From: Laura Gibbons <Laura.Gibbons@arun.gov.uk>
Sent: 20 September 2019 15:50
To: Anita Gardner <Anita.Gardner@arun.gov.uk>
Subject: RE: Scyld, Horsemere Green Lane. CM/21/19/PL: Drainage Comments

Subject: Scyld, Horsemere Green Lane. CM/21/19/PL: Drainage Comments

From: Laura Gibbons <Laura.Gibbons@arun.gov.uk>
Sent: 18 September 2019 13:29
To: Anita Gardner <Anita.Gardner@arun.gov.uk>
Subject: RE: Scyld, Horsemere Green Lane. CM/21/19/PL

drawing number **MBSK190628-01** rev. **P1**

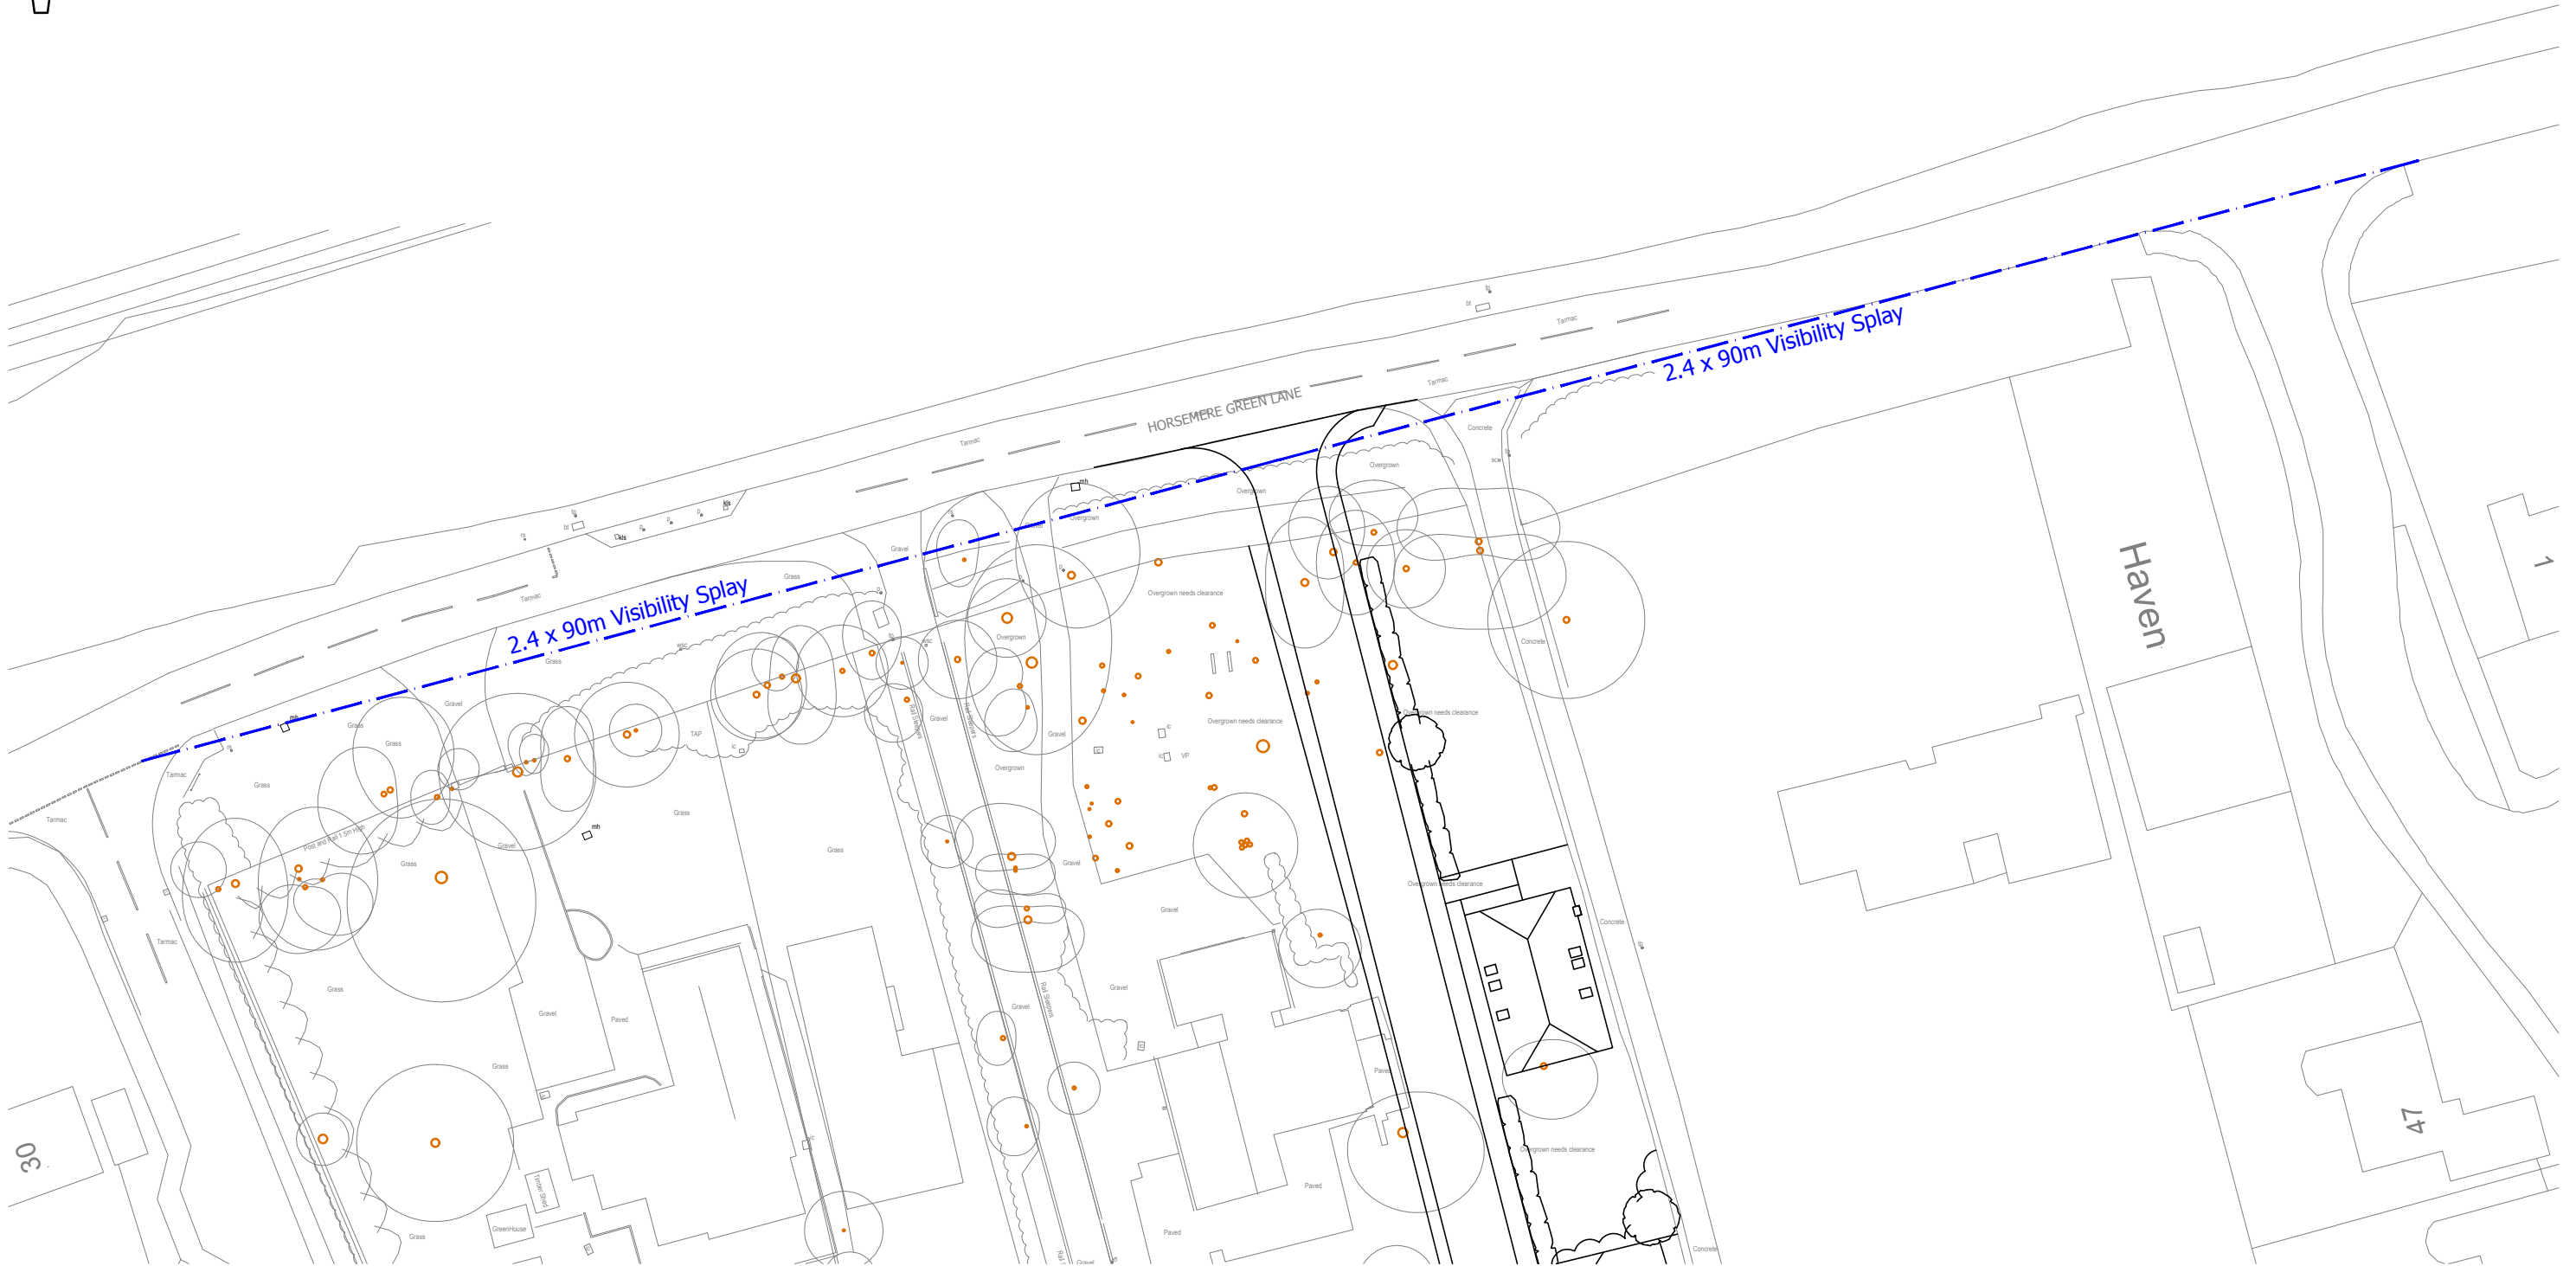
It is still not demonstrated that an attenuation solution can be provided if it is found that infiltration does not work. I require some brief calculations of greenfield runoff rate and required storage volumes. I also require a rough layout to be produced showing where this storage could be provided, and where it would outfall to.

No infiltration testing results or groundwater monitoring results have been provided to date. Without these we require an attenuation scheme to be drawn up to demonstrate that the site can be adequately drained, taking consideration of the proposed layout, if it is found that infiltration does not work. The drainage strategy should be updated to state an attenuation scheme has been provided to demonstrate that drainage for a worst case scenario is feasible but that infiltration will be utilised where possible. Pumping should be avoided. Potential options to consider for shallow conveyance of water could include; swales, oversized pipes, conveyance through permeable paving etc.
